TO	Nicole Brewer, Director, Energy Assessments
FROM	Mark Davey
DATE	17 July 2026
OUR REFERENCE	0617753
SUBJECT	Keri Keri Wind Farm (SSD-3858962) Request for Additional Information

Keri Keri Wind Farm (SSD-3858962)–Request for Additional Information

Ref No	Theme	Submission	Response	Where Addressed
TfNSW-01	Traffic (generation)	1. Preconstruction Minor Works for workers accommodation camp traffic assessment requirements. A complete assessment of the wind farms and workers' accommodation camp construction pre-construction minor works is required and is to include: - Assessment of traffic volumes and identification of the types of vehicles that will be used during this period, including the largest design vehicle. - Perform a swept path analysis for the largest heavy vehicle at the existing intersection, ensuring it can navigate within the current pavement. If the design vehicle cannot turn easily, implement necessary mitigation or temporary works. - Assess existing Safe Intersection Sight Distance (SISD) and propose measures to achieve compliance, - Identify AM/PM peak hour traffic volumes and proposed volumes during this time. Traffic volumes during the AM/PM peak hours are to be c

Keri Keri Road/Sturt Highway
Concept Design - Staggered Intersection With BAL / CHR(s)
Keri Keri Wind Farm

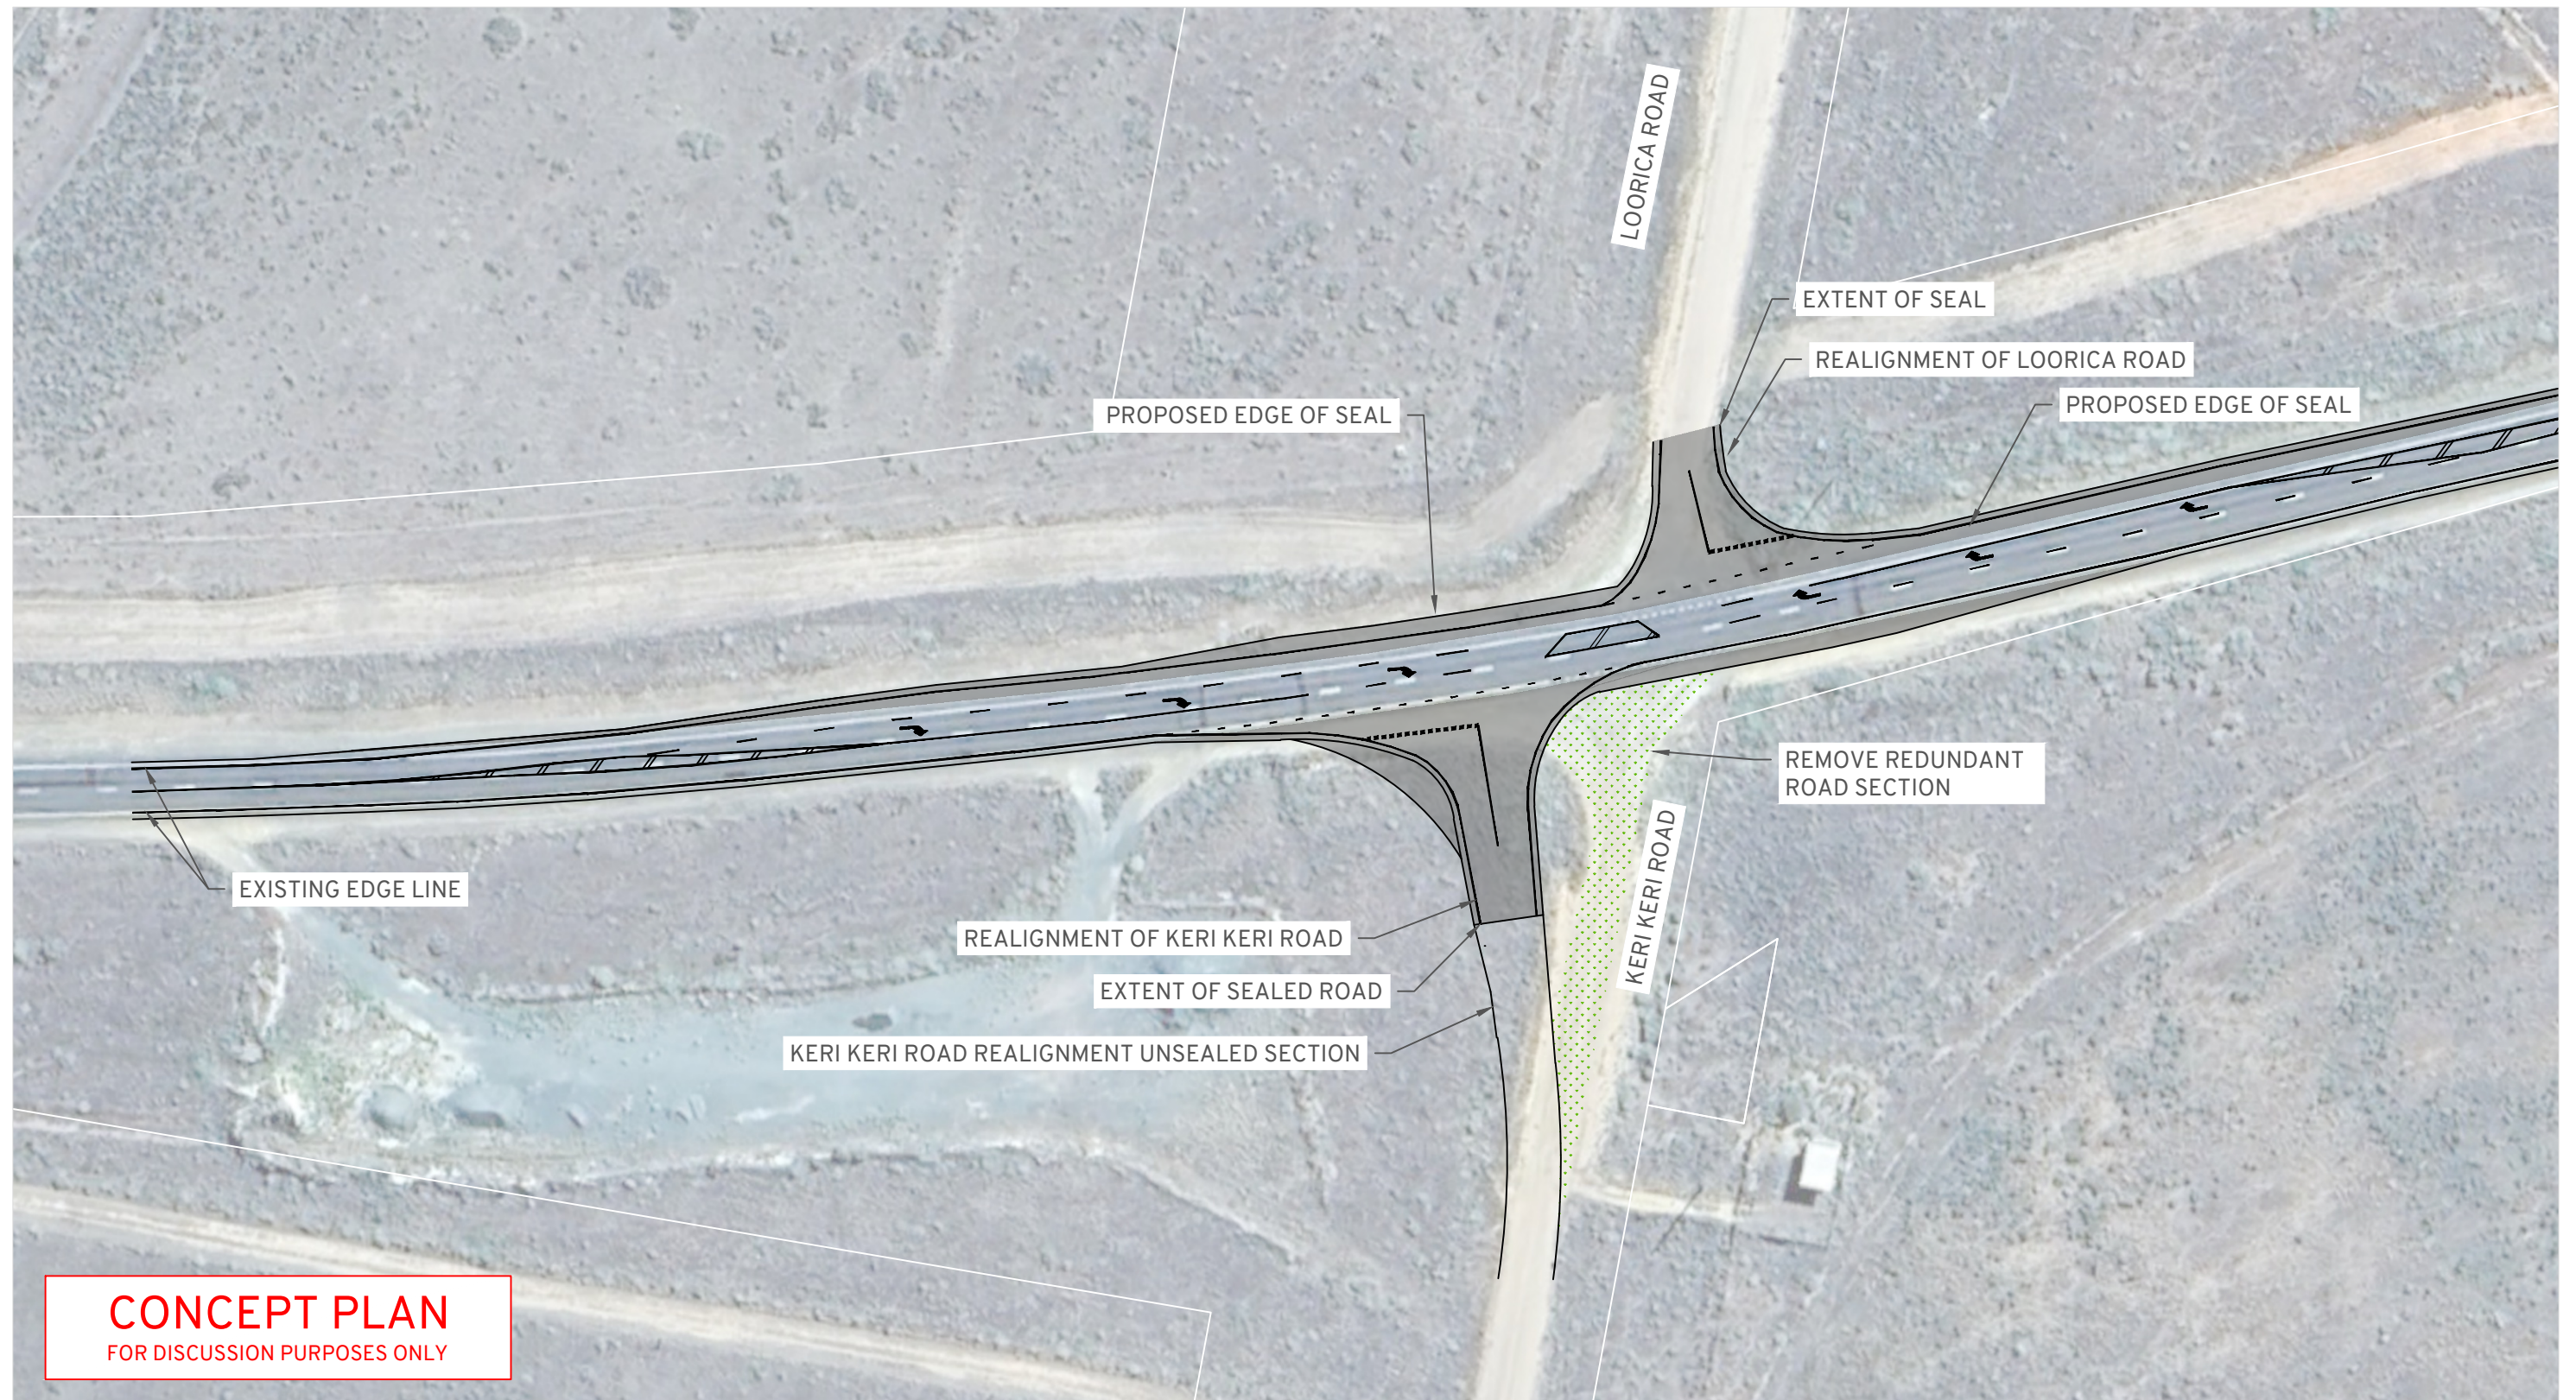
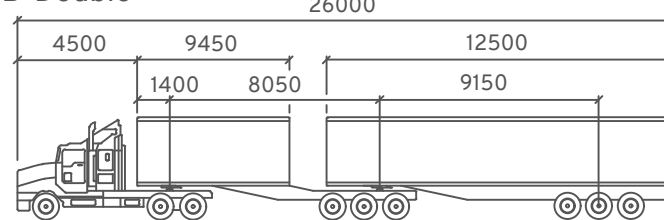
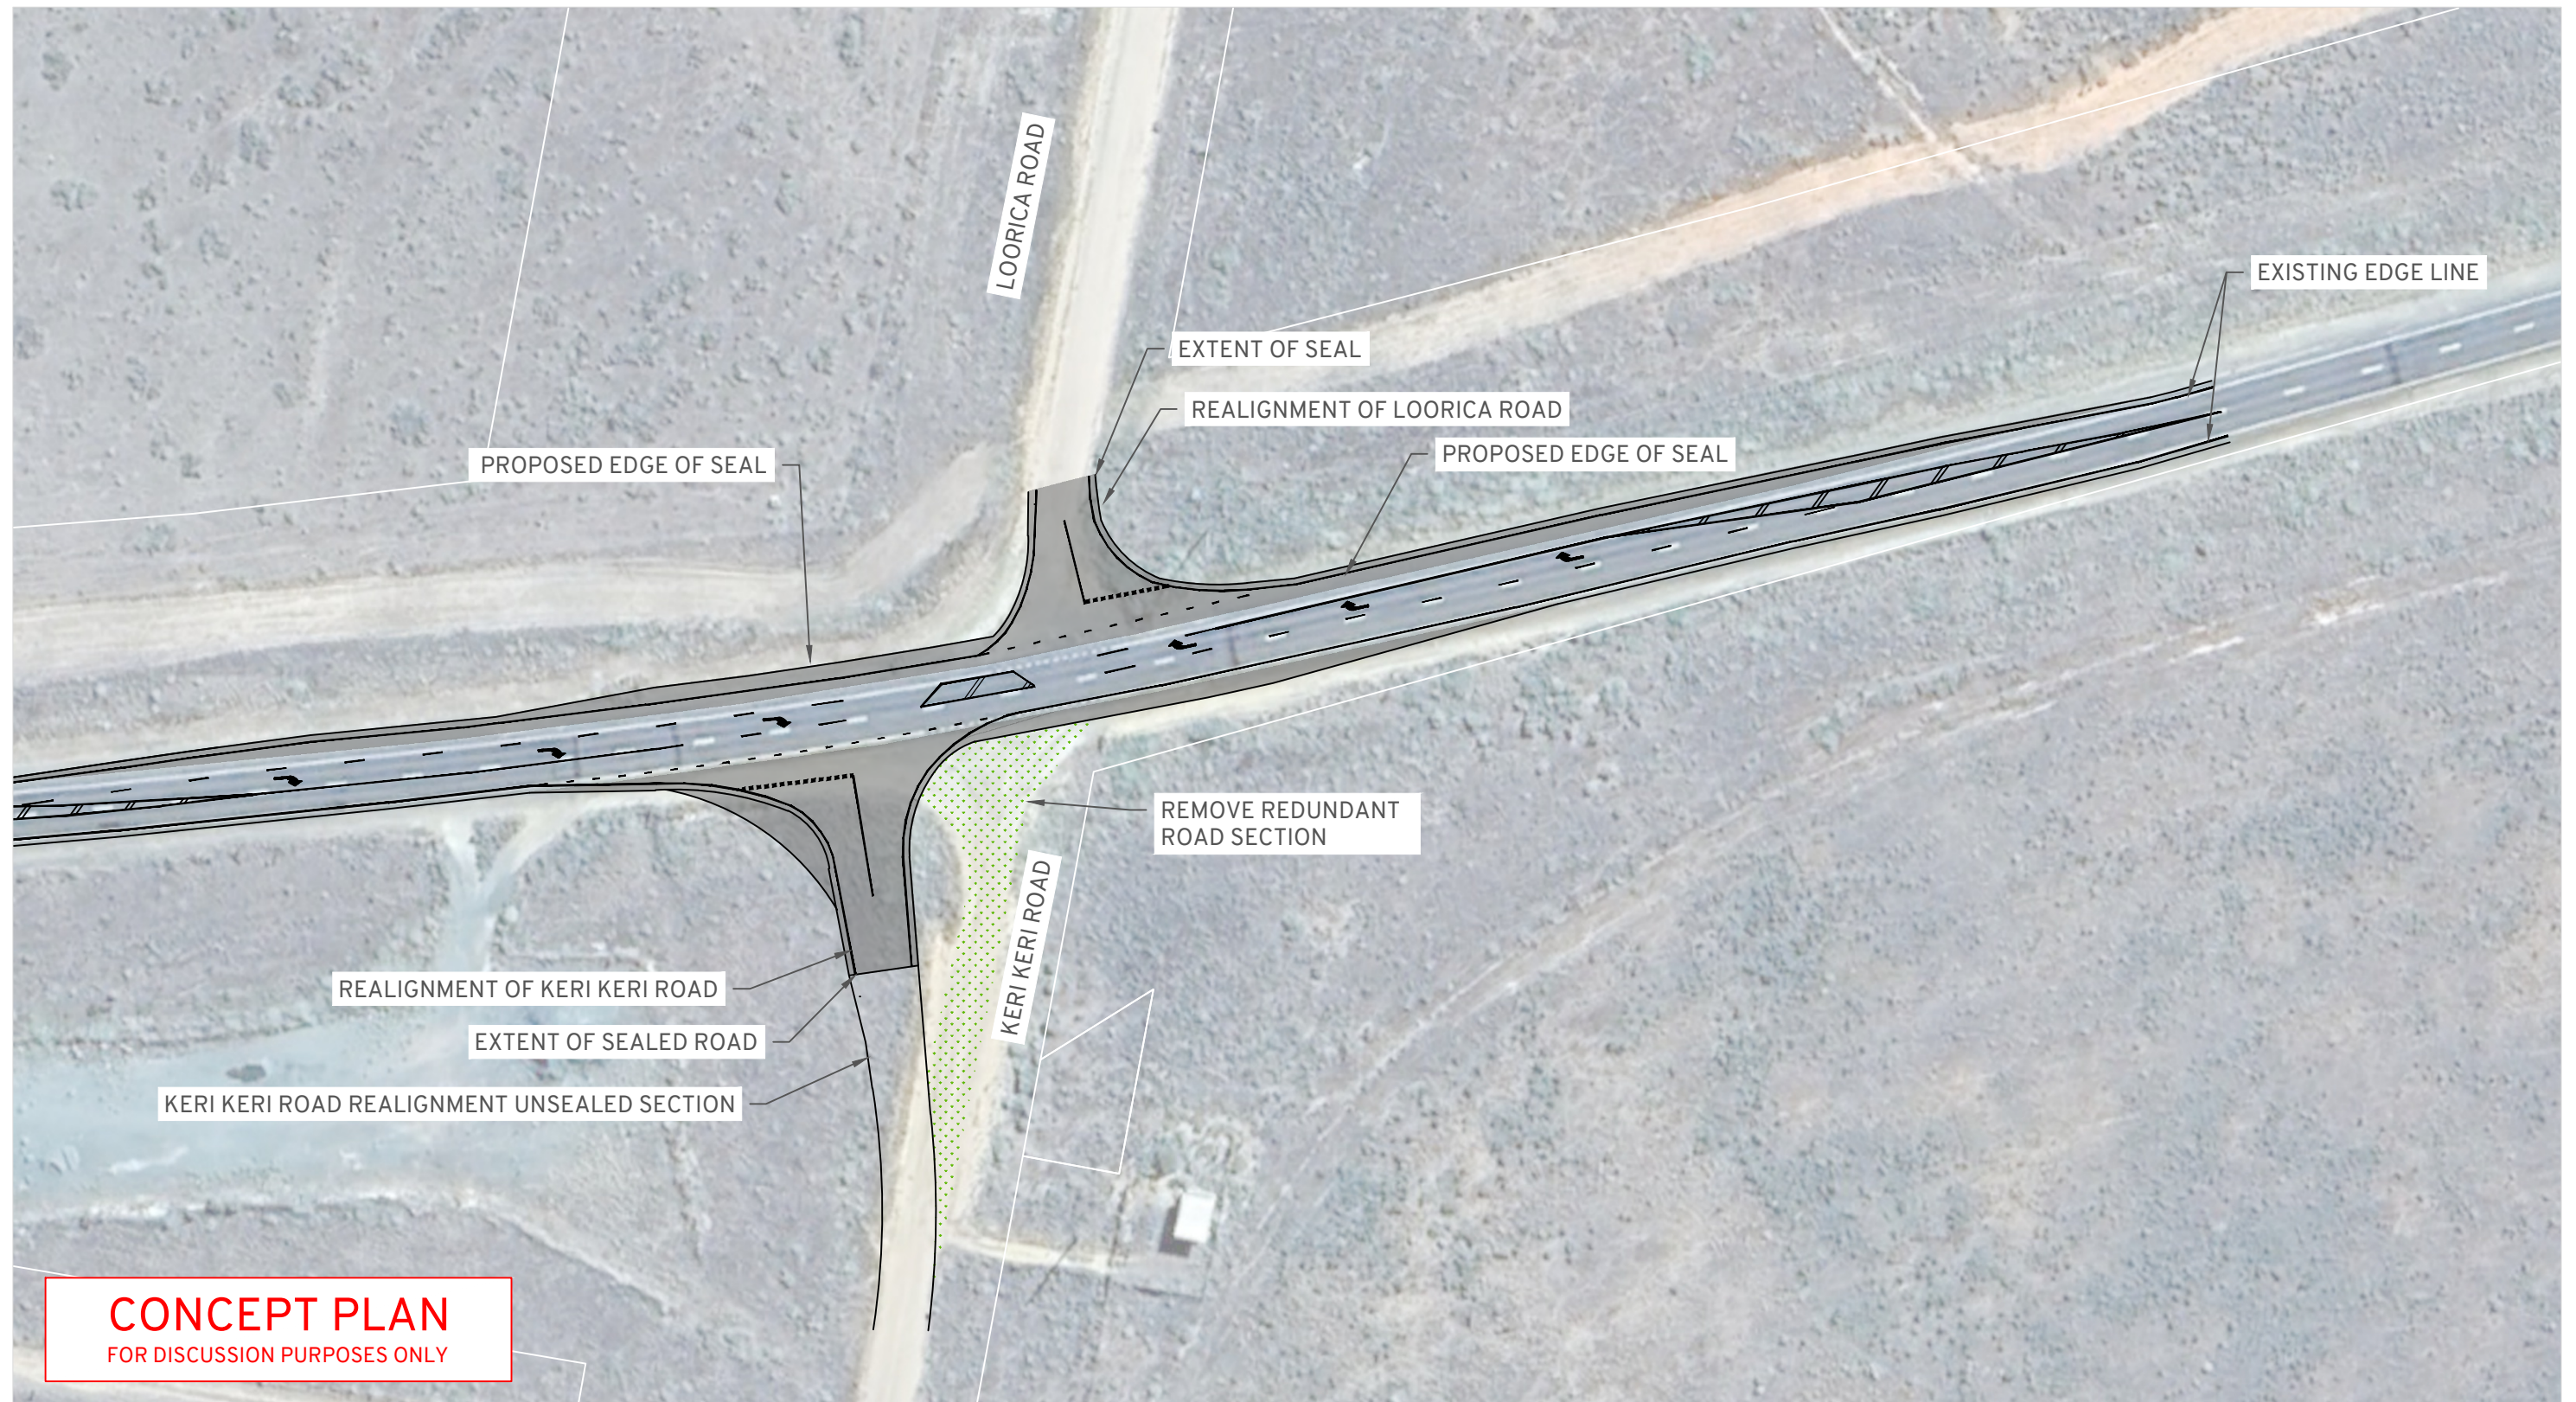
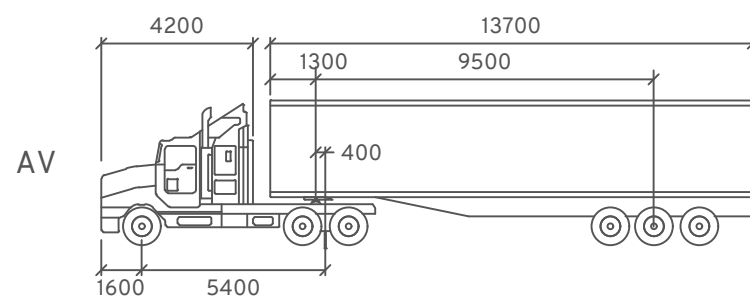
Ref No	Theme	Submission	Response	Where Addressed
		f. Revision D, Civil Design RJ Andrews SPA - Keri Keri Road intersection - A hardstand strategic concept design will be required prior to determination to confirm the impacts on the Sturt Highway and how it will interact with Keri Keri Road. How will the hardstand be managed to reduce the likelihood that light vehicles will use the hardstand daily?	An updated strategic concept design for this intersection is provided in Appendix C. The OSOM hardstand area has been reduced significantly, and edge line marking would direct light vehicles to remain within the marked lane.	Appendix C of the Amended TIA (Attachment D)

k. Revision D, Civil Design, 21012CAD003 Figure 9 - Keri Keri Road - The intersection of Sturt Highway, Keri Keri Road and Loorica Road is a four-way intersection. This arrangement is undesirable, as road users may not perceive that they are approaching an intersection and may continue through, increasing the likelihood of a side-impact crash. Austroads Guide to Road Design provides guidance on modifying four-way intersections to a staggered T intersection to mitigate this risk. Due to this development, traffic on Keri Keri Road will increase significantly, increasing the likelihood of this crash type. l. Revision D, Civil Design 21012CAD003 Figure 9 - Keri Keri Road -The intersection angle is 70 degrees, which is allowable by the standards; however, it is the absolute minimum. Is there an opportunity to better align Keri Keri Road with the Sturt Highway?	Revised strategic concept design for this intersection is provided in Appendix C. The design includes realignment of the minor road approaches to form 90-degree staggered T-intersections with BAL and CHR(s) treatments for each approach.	Appendix C of the Amended TIA (Attachment D)
